Application no: **3/2021/0240**

Address: **Bowland Wild Boar Park Wardsley Road Chipping PR3 2QT**

Proposal: **Discharge of condition 6 (Construction Management Plan) of planning application 3/2020/0579**

Site plan

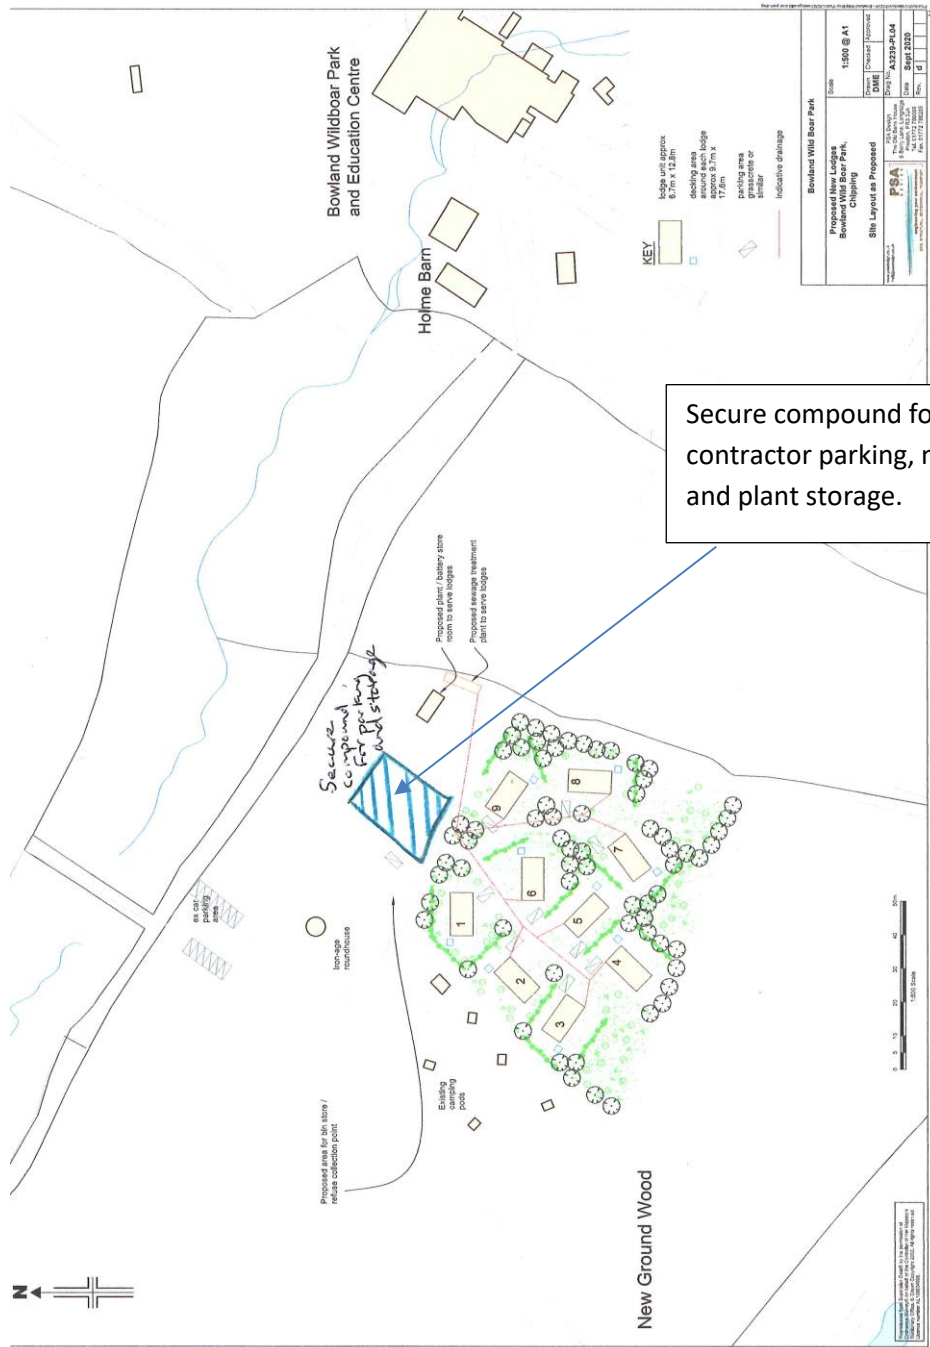
It is also said that all goods will be unloaded adjacent to the development site. However, any unloading of goods would need to be carried out within the boundaries of the development site.

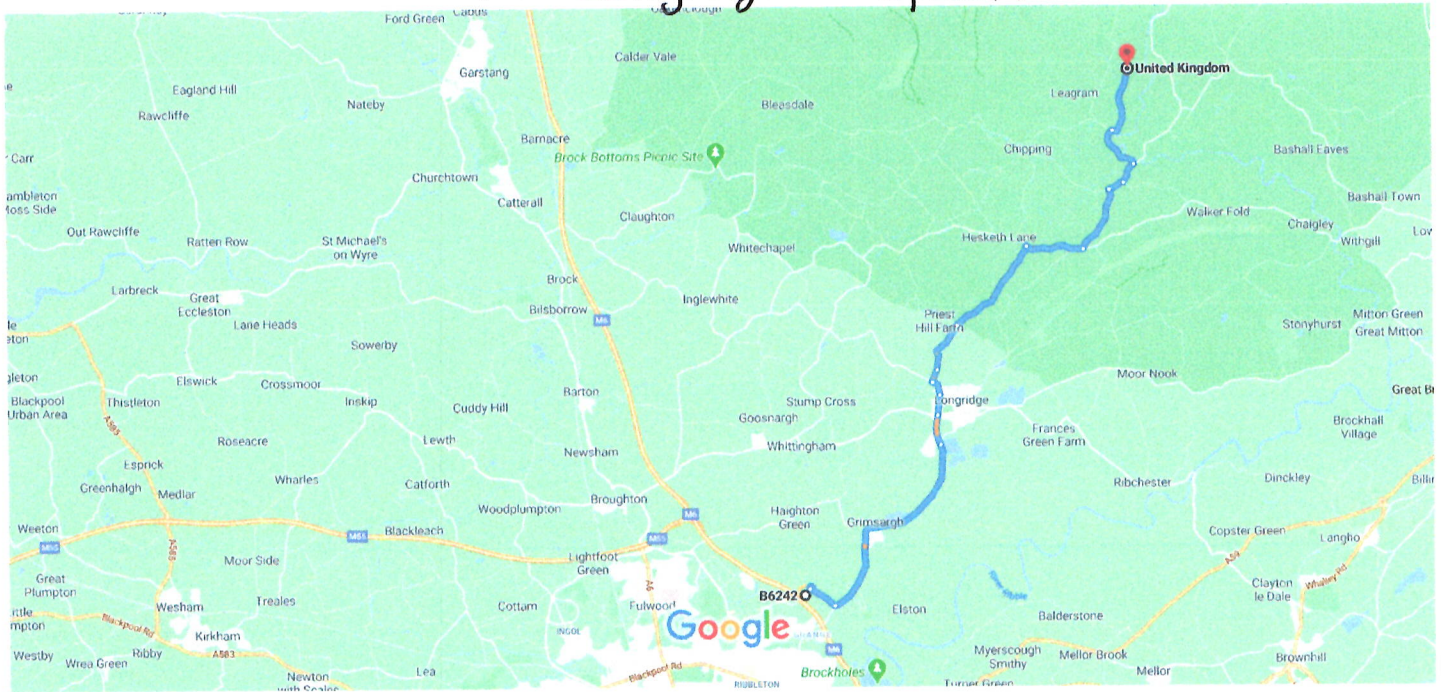
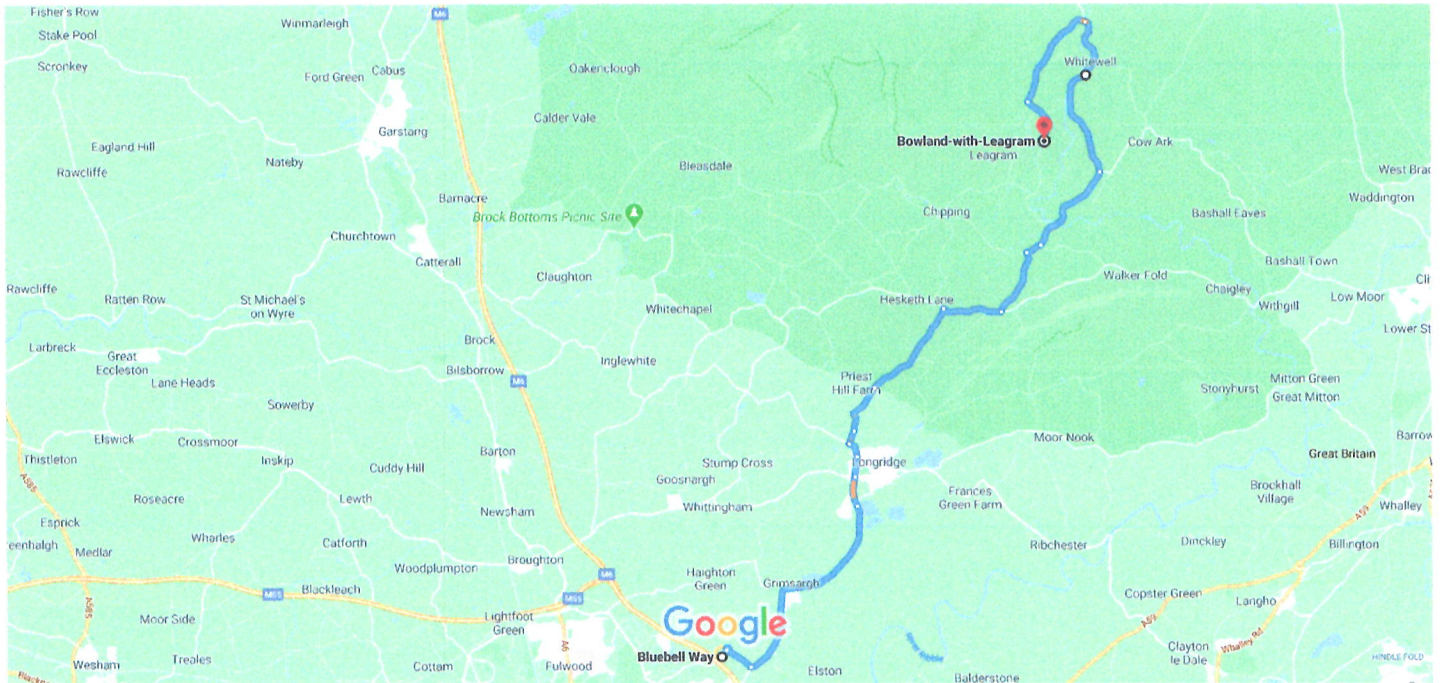
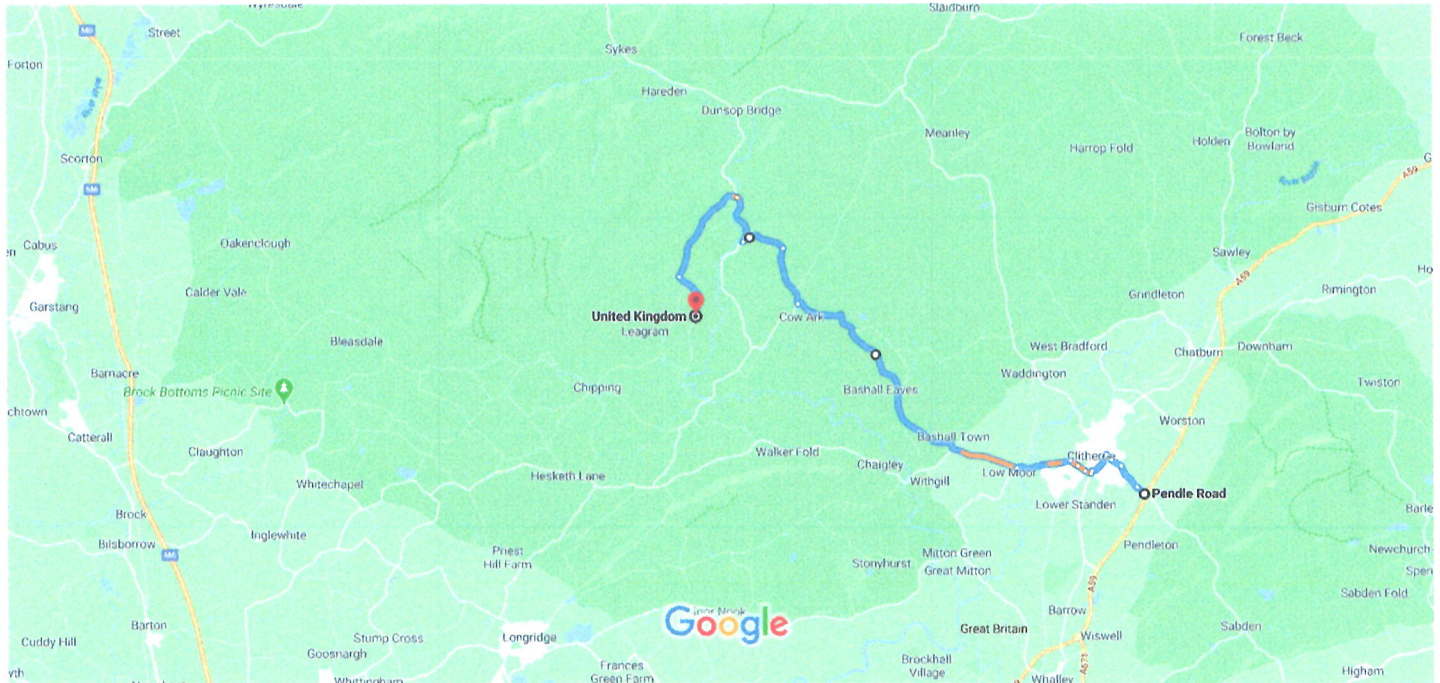
The transport routing plan requires further consideration, a designated route is paramount to the safe delivery of the proposed development and provides clear instruction for deliveries to and from the application site. A dedicated transport routing plan along with set hours for those deliveries as mentioned above would help to provide minimal disruption throughout the course of the development proposal on the local highway network. Providing a routing option as proposed would not satisfy the terms of the condition and the transport routing plan would need to be more specific.

I ask that further clarification is provided and that the construction method statement along with the transport routing plan is revised to satisfy the terms of the condition.
